Re: VR-18-011 Resubmittal

Please see below responseS to El Paso County's comments regarding the submittal for file VR-18-011.

CLAREMONT RANCH
FILING NO. 9C

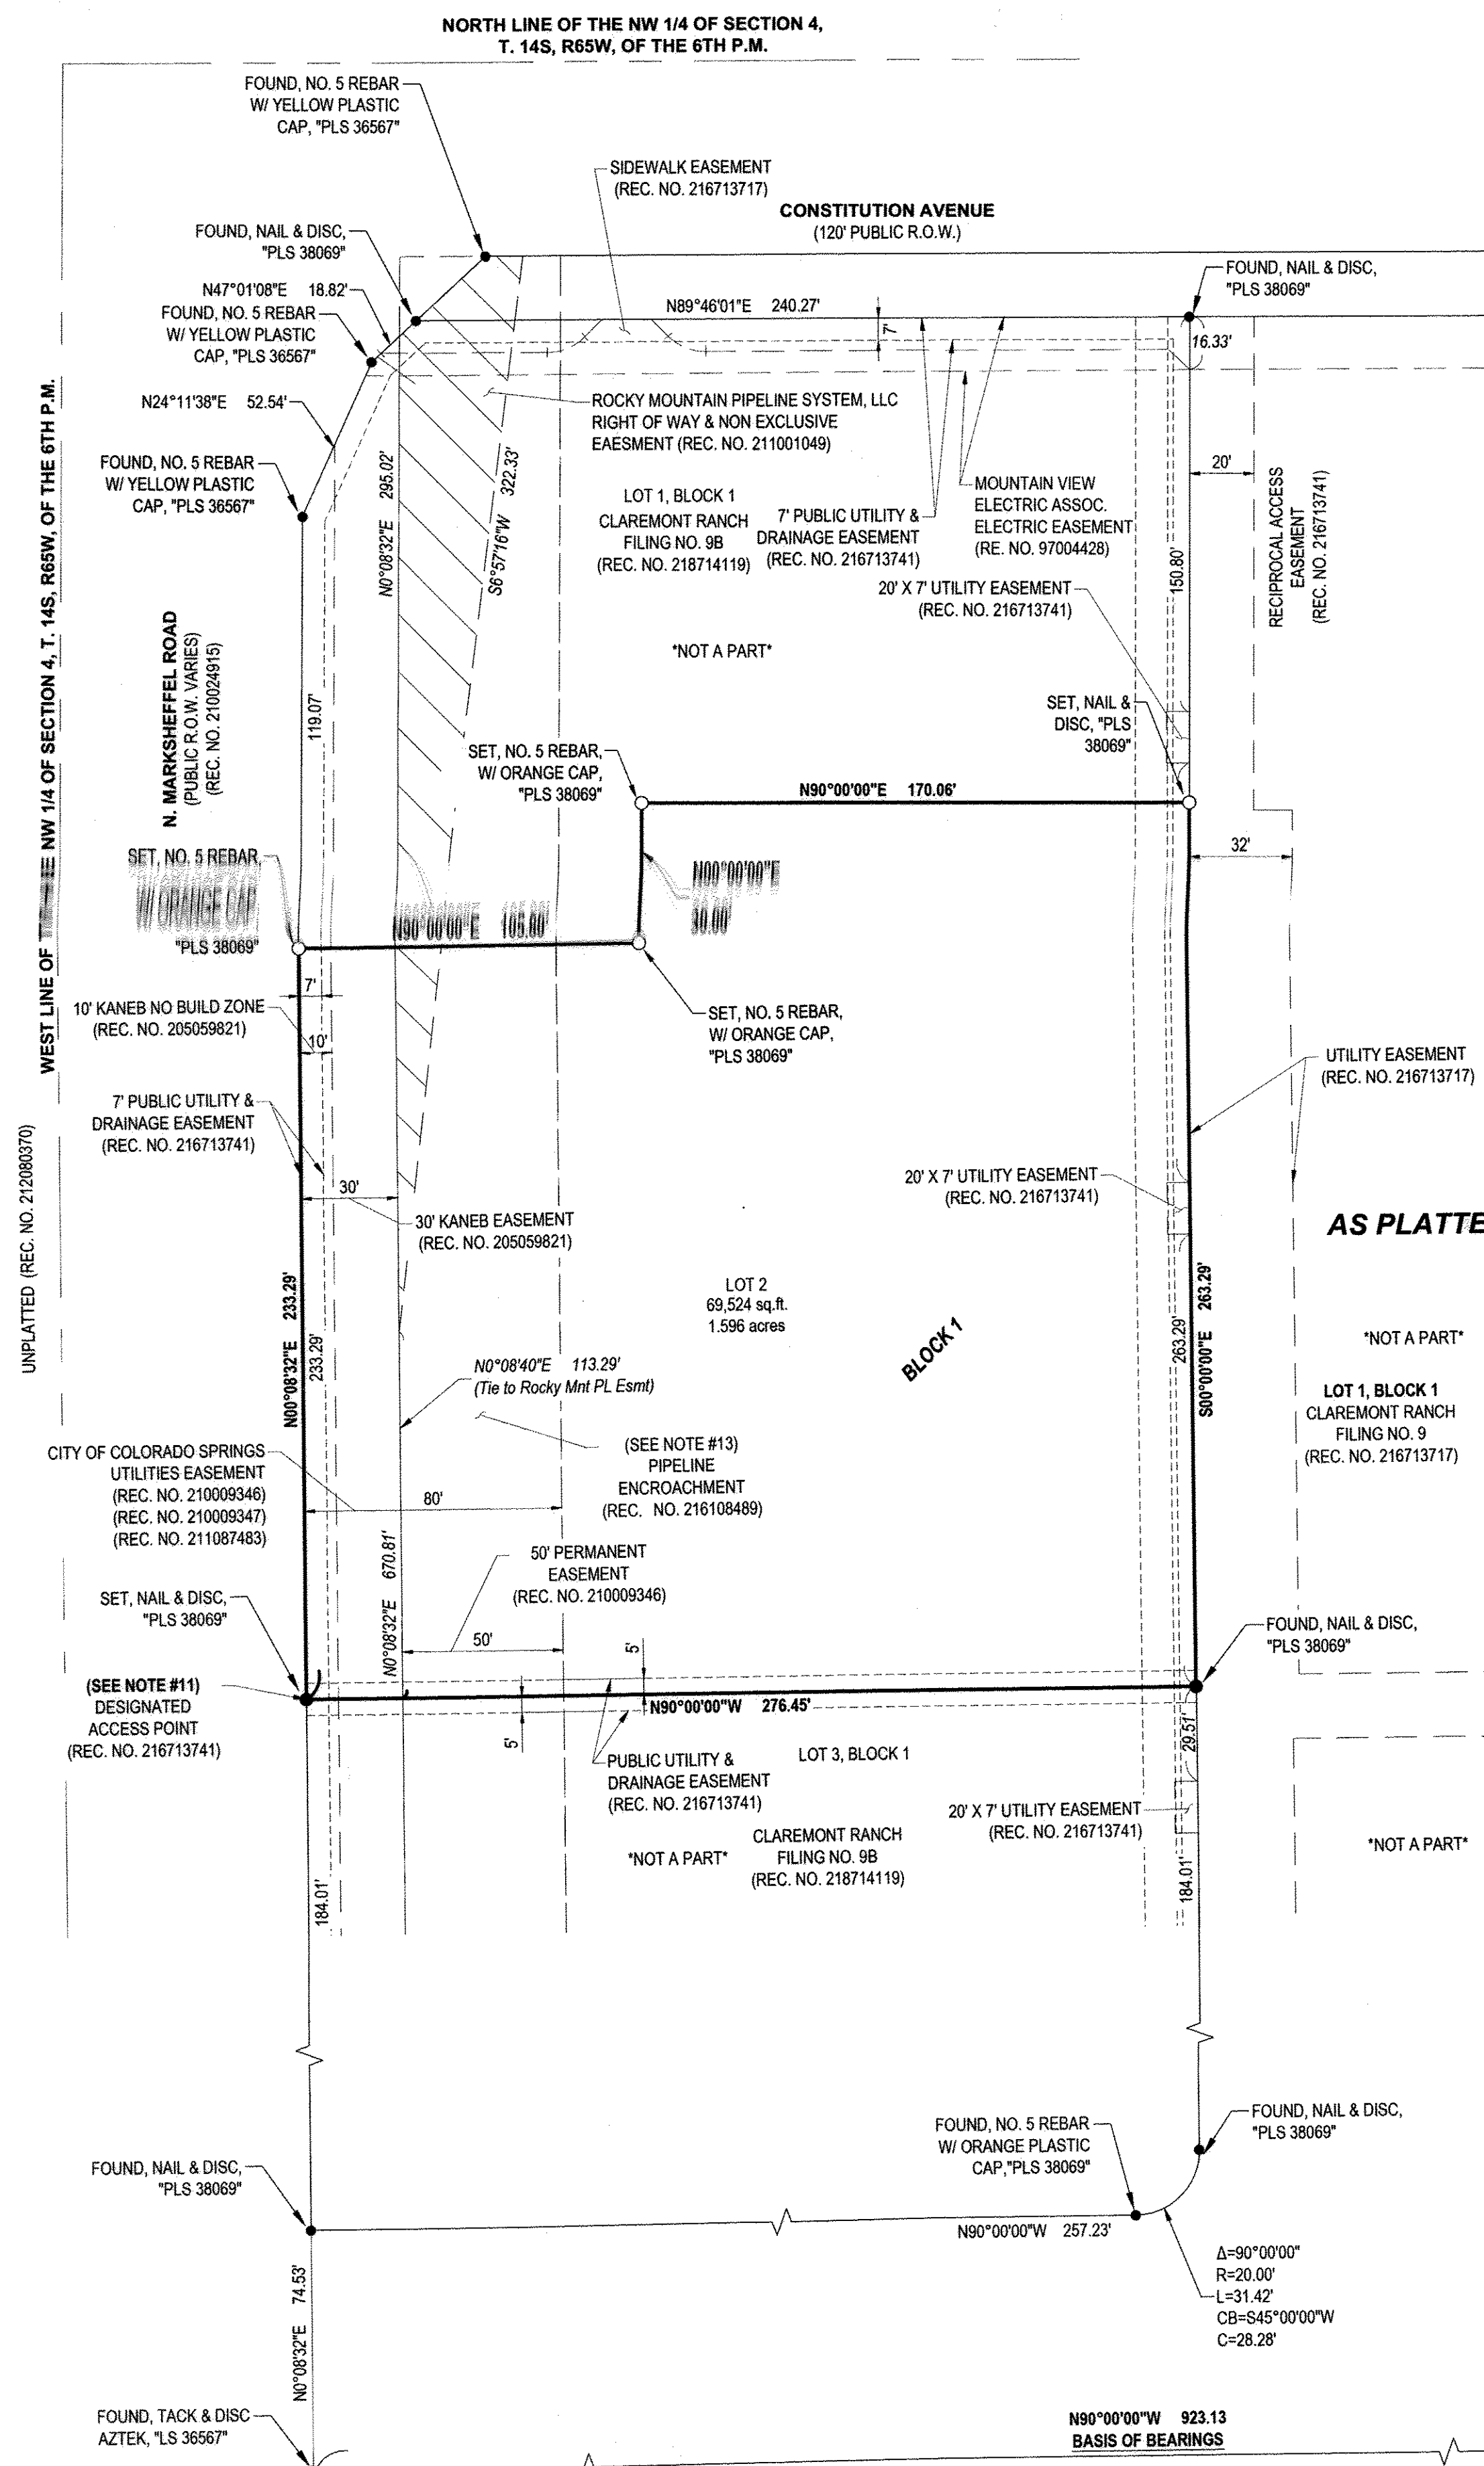
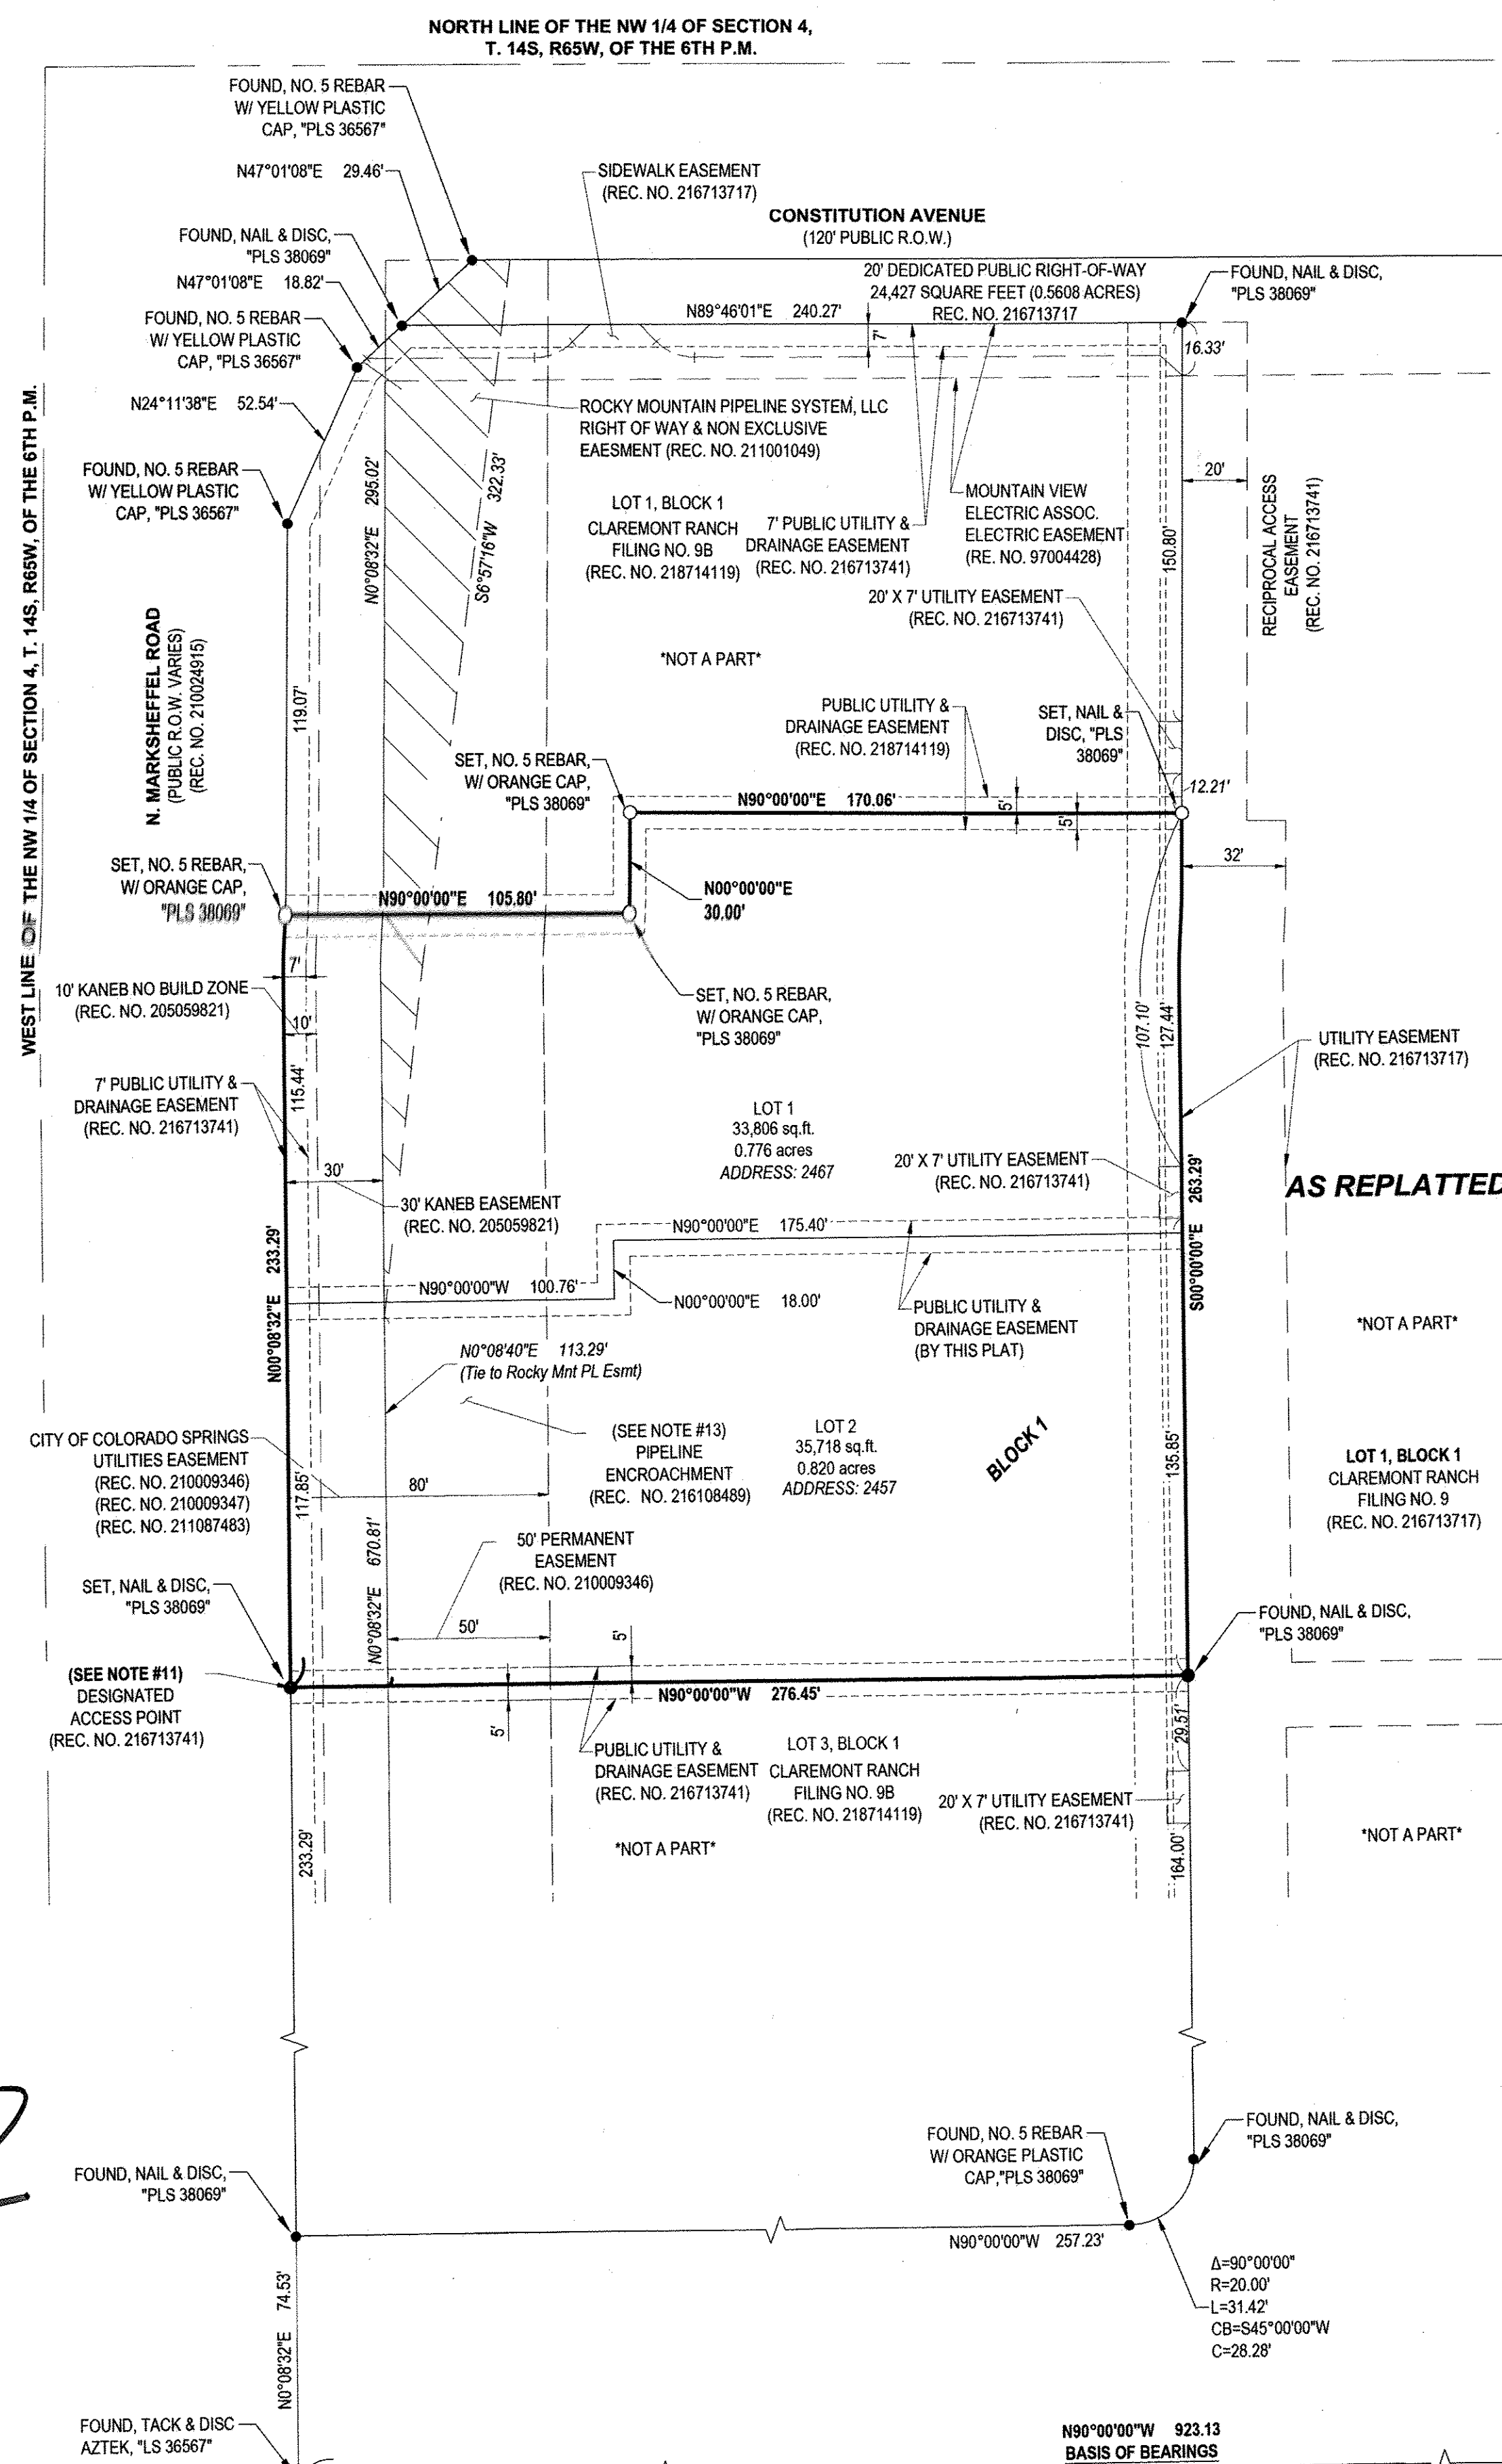
Regarding a request for approval of a final plat for Claremont Ranch Filing No. 9C, Enumerations has the following comments: **1)** Per Regional Building Code section RBC312.8, addresses must appear on plats. The address for lots 1, 3 and 4 should appear on the plat as they are currently addressed. Lot 2B should show the address which is currently assigned for Lot 2 of Claremont Ranch Filing No. 9B which is 2457 N. Marksheffel Rd. Lot 2A should show the address of 2467 N. Marksheffel Rd. **2)** The range shown in the title block of this plat is incorrect. This parcel is in Range 65. **3)** Standard final plat comments apply. The

*RESPONSE: Revised survey includes addresses and corrected range.*
